Boston Alternative Energy Facility

Response to Environment Agency's queries on Critical Infrastructure and Levels across the Application Site

Document Reference: 9.40

Date: 06 December 2021

TITLE
**ENVIRONMENT AGENCY
FLOOD ZONES
FIGURE 13.2**

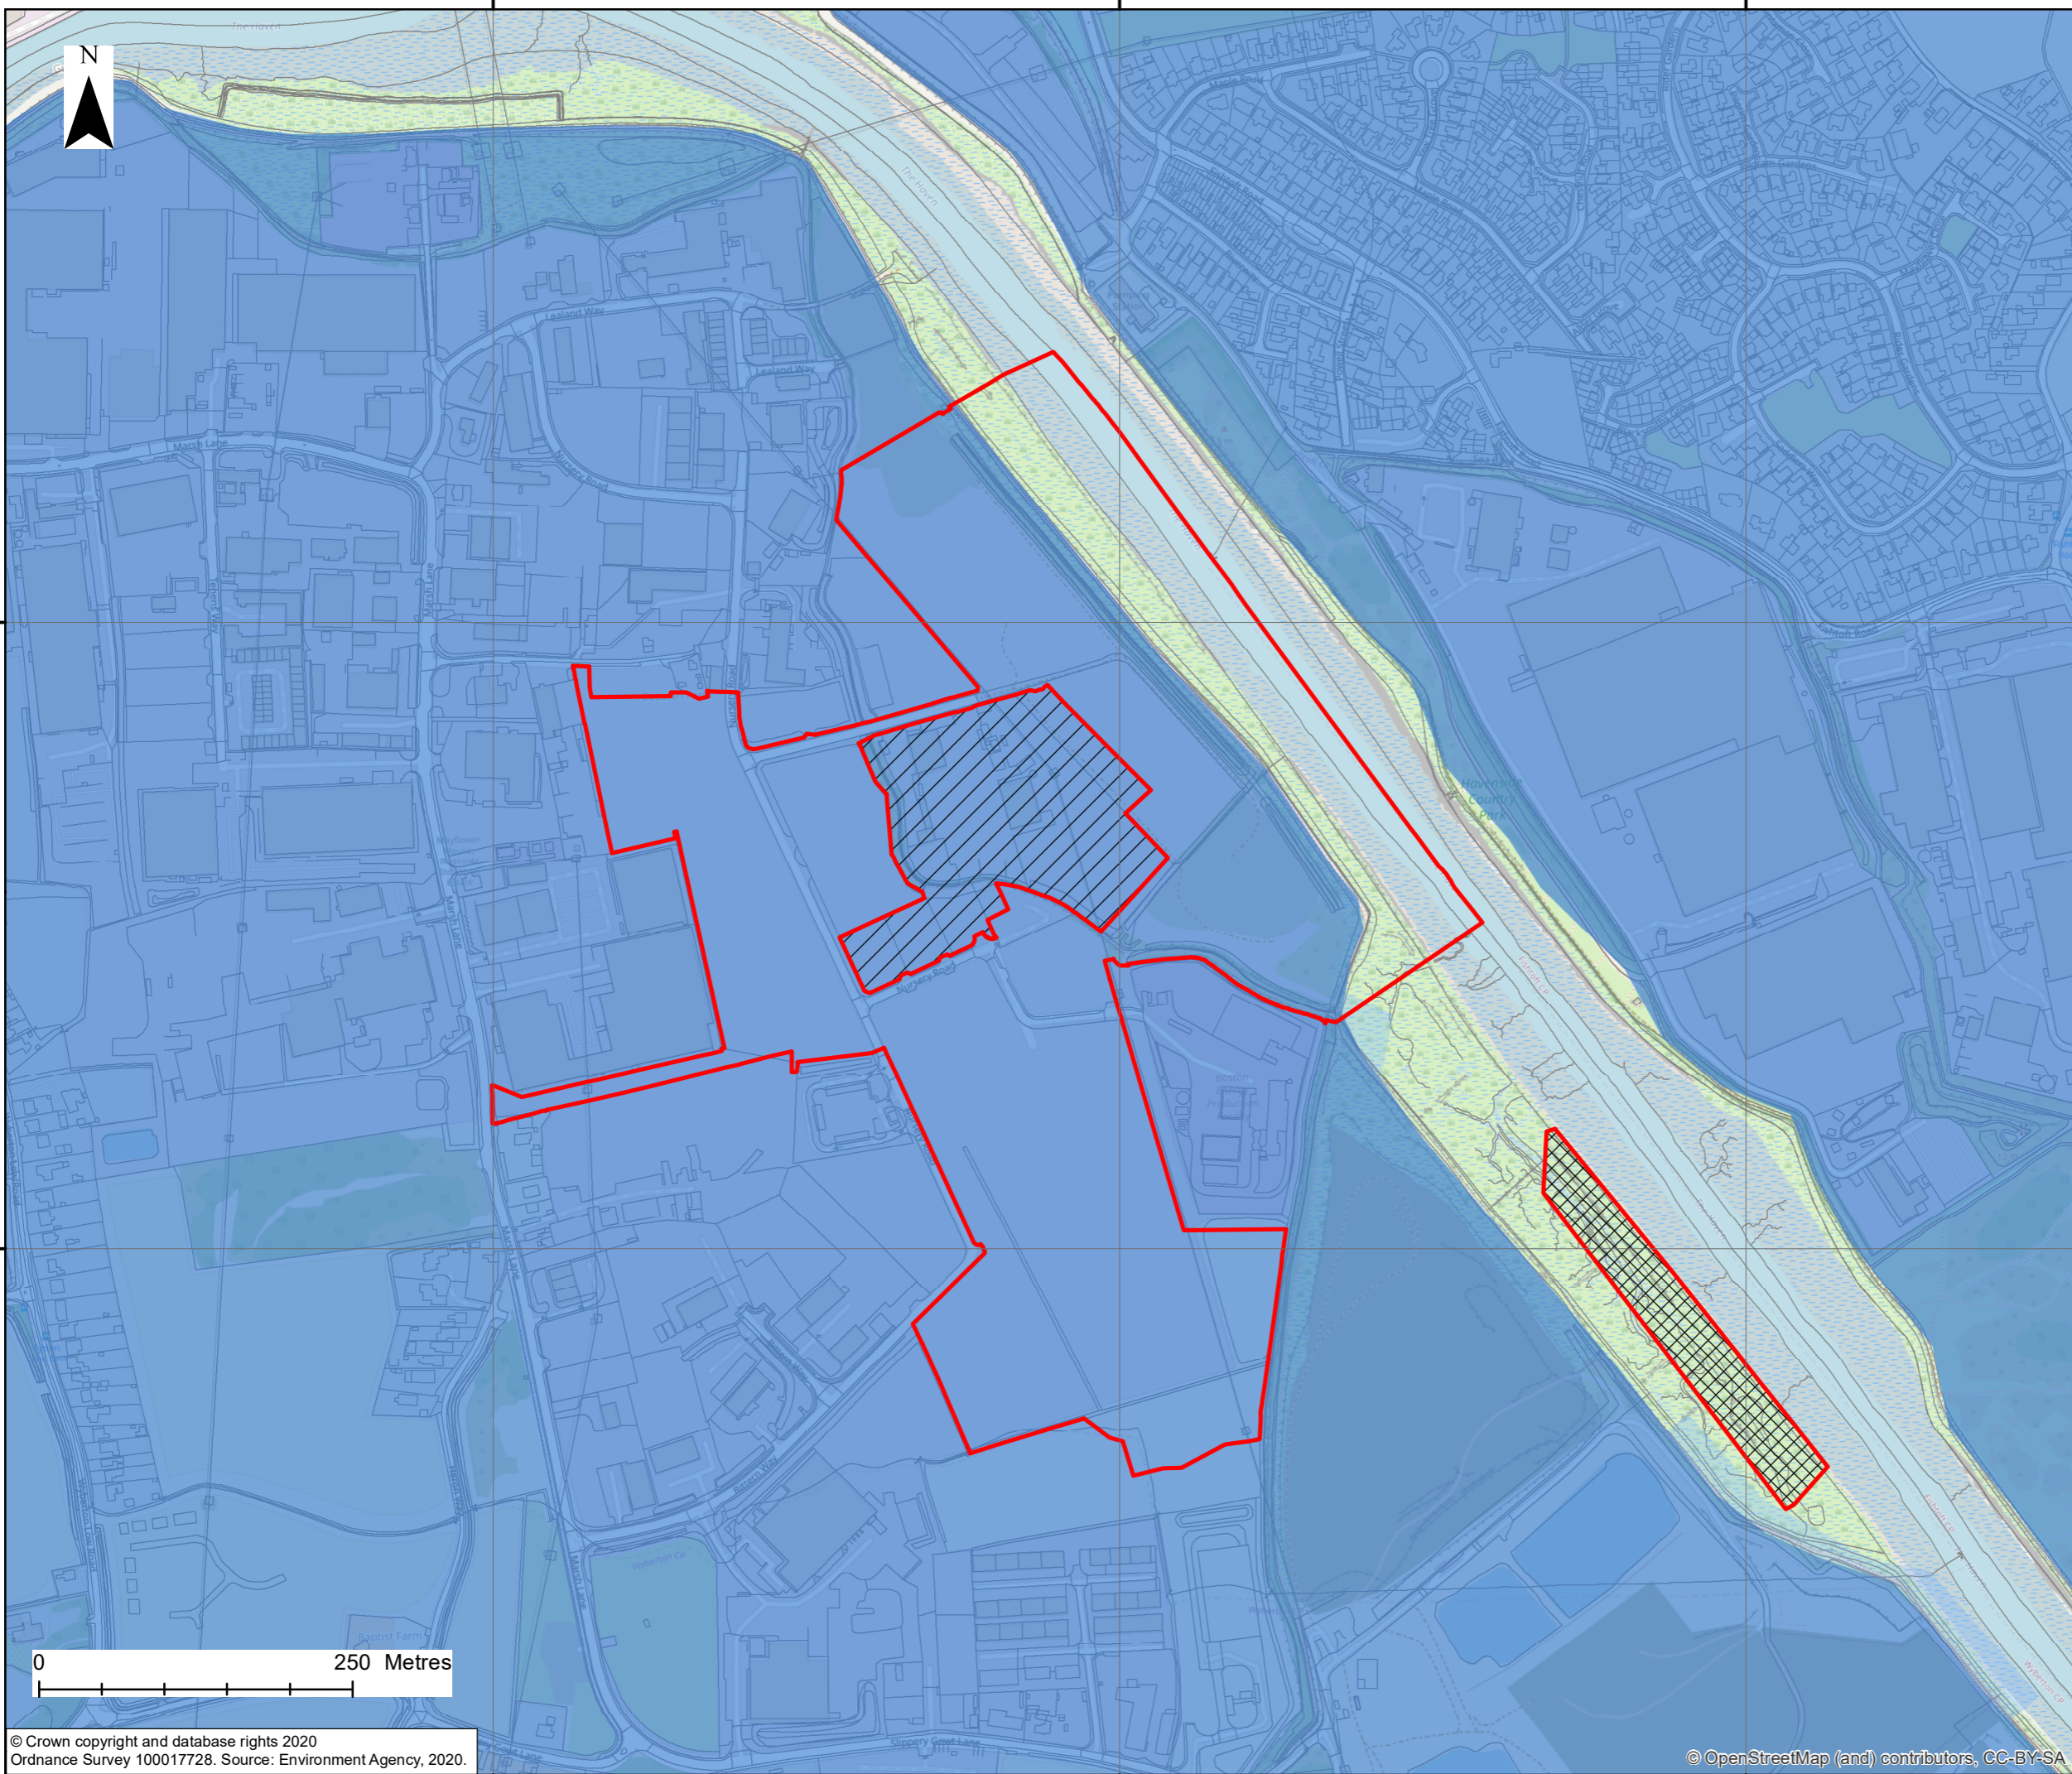
- 3.3 *We require details of finished site levels including assessment of any impact on the flow of water over the site. The Applicant has indicated to us that approximately 0.5 m of surface material will be removed and replaced with 0.8 m of surcharged material across the main site. This gives a net gain of 0.3m over the whole site. We require further assessment of the impact on flood risk to third parties through the displacement of flood waters.*

- 3.4 *Notwithstanding paragraphs 13.1.127 to 13.1.133 of the FRA (document reference 6.4.13, APP-106), we do not consider that the impacts of flooding on any critical infrastructure within the site has been adequately considered. We require further clarification about what aspects of the development are considered critical, and what mitigation measures are in place to protect them. We recommend that any features considered to be critical infrastructure should be raised above the predicted flood level to ensure it is protected in the event of a flood.*

With regard to the issues set out in Paragraph 3.3 of the Environment Agency's Written Representations (REP1-051), the finished site ground levels will be subject to minor variations across the Application Site. Existing ground levels to the riverward side of the Roman Bank / secondary defence (but landward of the primary flood defence) are between approximately +3.2m AOD and +3.5m AOD, whilst ground levels across the Principal Application Site to the rear of the Roman Bank / secondary defence are approximately +2.5m AOD.

As noted by the Environment Agency, the Applicant has confirmed the need to remove approximately 0.5m of surface material and replace this with approximately 0.8m of surcharged material during construction. This will aid in the levelling of the site and setting out of the buildings. This approach is in accordance with that adopted for the adjacent Boston Biomass No. 3 site. Principally, buildings within the Application Site will be set at ground level (with machinery / equipment elevated inside the buildings), although the Applicant also notes that for key buildings there will be a requirement to provide localised slabs / platforms upon which the buildings and equipment will be mounted. Details related to site levelling, access roads

Further to the above, with reference to the concerns expressed in Paragraph 3.3 by the Environment Agency (REP1-051) related to the displacement of flood waters, the Applicant notes that the Facility is to be located behind the existing flood defences which provide significant protection not only to the Application Site, but also the wider area including the town of Boston.

As indicated in the Applicant's Comments on the Examining Authority's First Written Questions (document reference 9.24, REP2-008) the present day flood risk to the Application Site is classed as a residual risk, due to the presence of the existing defences. As such during the present day extreme event water would not affect the Application Site and therefore the development of the Facility would not result in the displacement of flood water from The Haven.

Based on the above, in response to the concerns expressed in Paragraph 3.3 of the Environment Agency's Written Representations (REP1-051), the Applicant does not consider there is any further assessment required in terms of potential impact on flood risk to third parties. The presence of both the existing and improved defences, to be delivered as part of both the Boston Combined Strategy and the development of the Facility, ensures there will be no displacement of flood waters during an event, up to and including the 1 in 300 year event in 100 years' time.
